26 July 2018

SWT18/00008
SF2018/022335
MM

SSD-9039 – PROPOSED SOLAR FARM, LOT 1 DP100773, LOTS 1-7 DP134511, LOT 103 DP752290, LOTS 114-116 DP752290, LOT 125 DP752290 AND LOT 132 DP752290, SAVERNAKE ROAD, MULWALA.

**Figure 7.4: Example of a rural property access specifically designed for articulated vehicles**

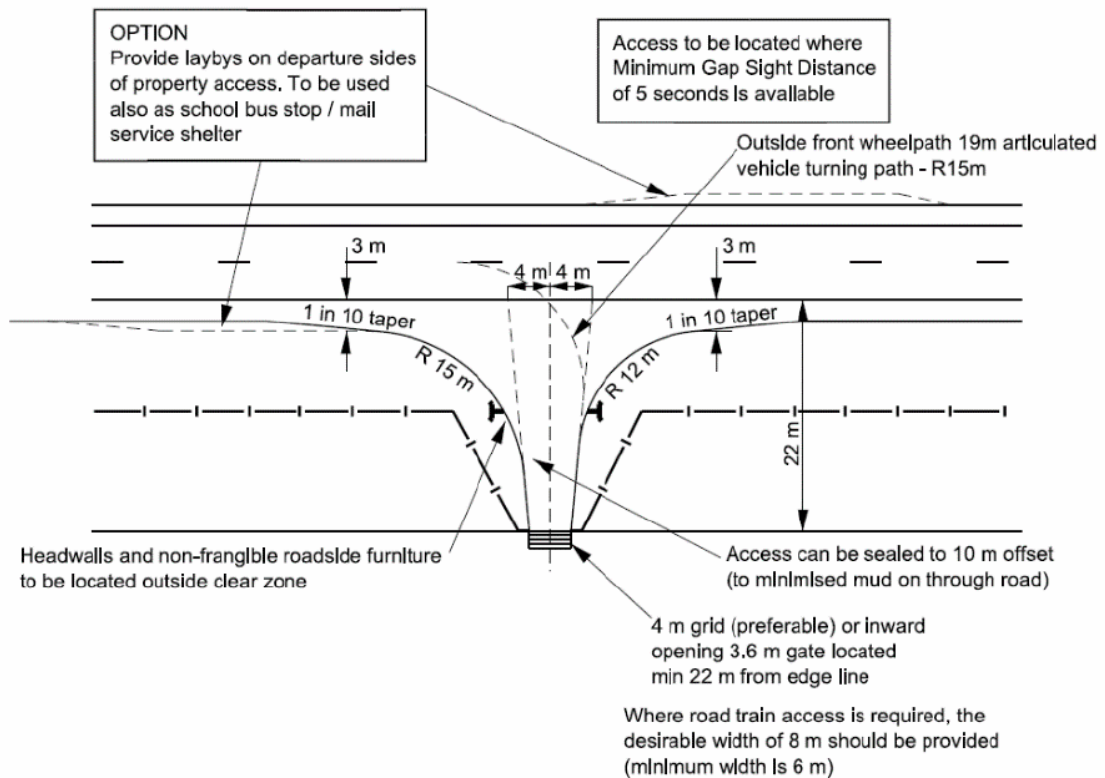
The submitted documentation indicates that access to the development site is proposed from Lambruck Lane and through the intersection of the Tocumwal Road and Savernake Road. However an access is also proposed from Tocumwal Road for the proposed Switching Yard. As the proposed development site will include internal access roadways and the terrain does not appear to represent any restrictions to access from Lambruck Lane to the switching yard it is appropriate to require that all access to the development site be via this access and deny access to the site from Tocumwal Road. This is consistent with the provisions of SEPP (Infrastructure) clause 101. The standard of the access to the site from Lambruck Lane should be consistent with Council's requirements.

2. Prior to the commencement of construction on-site, the Proponent must undertake all works to upgrade any road, its associated road reserve and any public infrastructure in that road reserve, to a standard suitable for use by heavy vehicles to meet any reasonable requirements that may be specified by the relevant roads authority.

**Figure 6.1: Mechanical Behaviour of the Proposal**

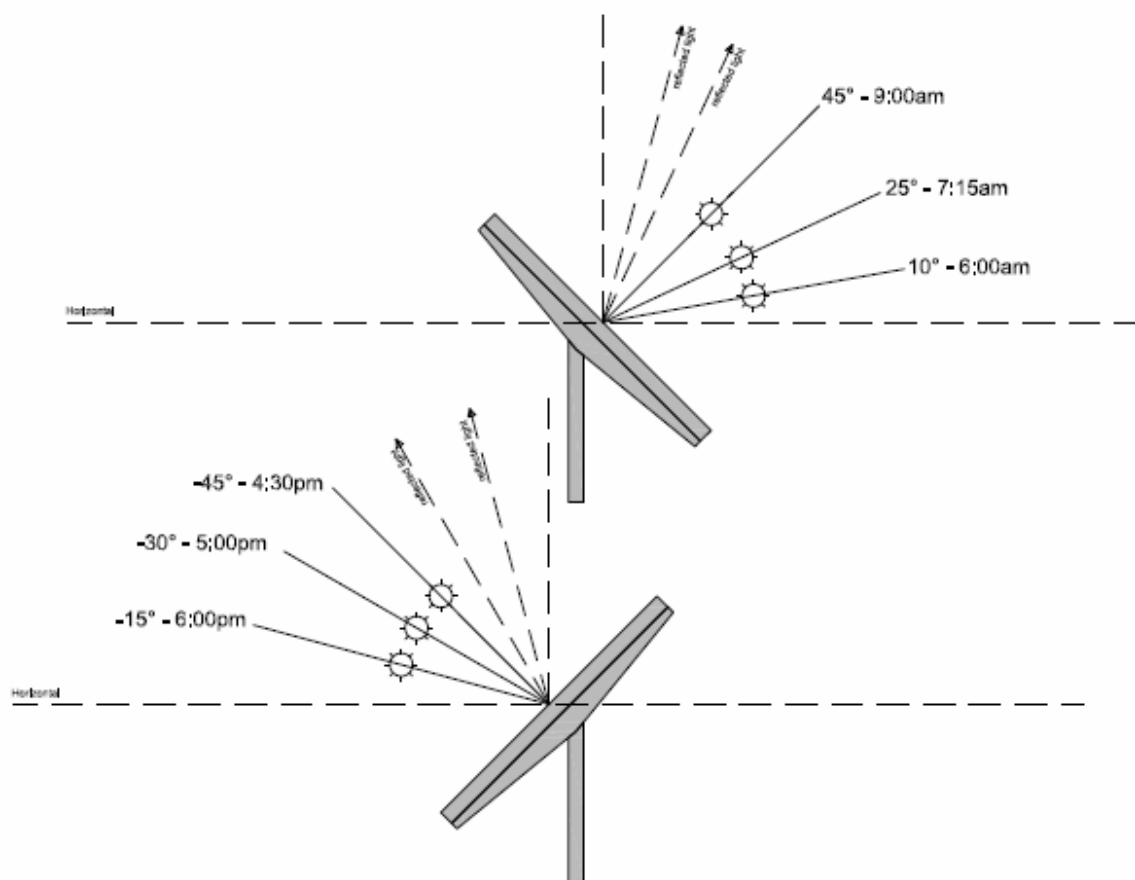
The submitted documentation claims that due to the design and orientation of the solar panels that glare and reflection from the solar farm infrastructure will have negligible influence on motorists and no adverse effect on traffic safety. Given the proposed design of the panels to follow the sun and the approach angle of Tocumwal Road from the west relative to the location of the solar farm there is potential for the development to cause distraction to the motorists on Tocumwal Road. The establishment of a visual screen, such as established plantings, to shield the development from view along Tocumwal Road, particularly on the western approach, would aid to minimise any perceived impact on distraction or glint/glare for motorists.

5. Glint and glare from the solar panels shall not cause a nuisance, disturbance or hazard to the travelling public on the public road network. In the event of glint or glare from the solar plant being evident from a public road, the proponent shall immediately deny rotation of the panels and implement glare mitigation measures such as construction of a barrier (e.g. fence) or other approved device to remove any nuisance, distraction and/or hazard caused as a result of glare from the solar panels.
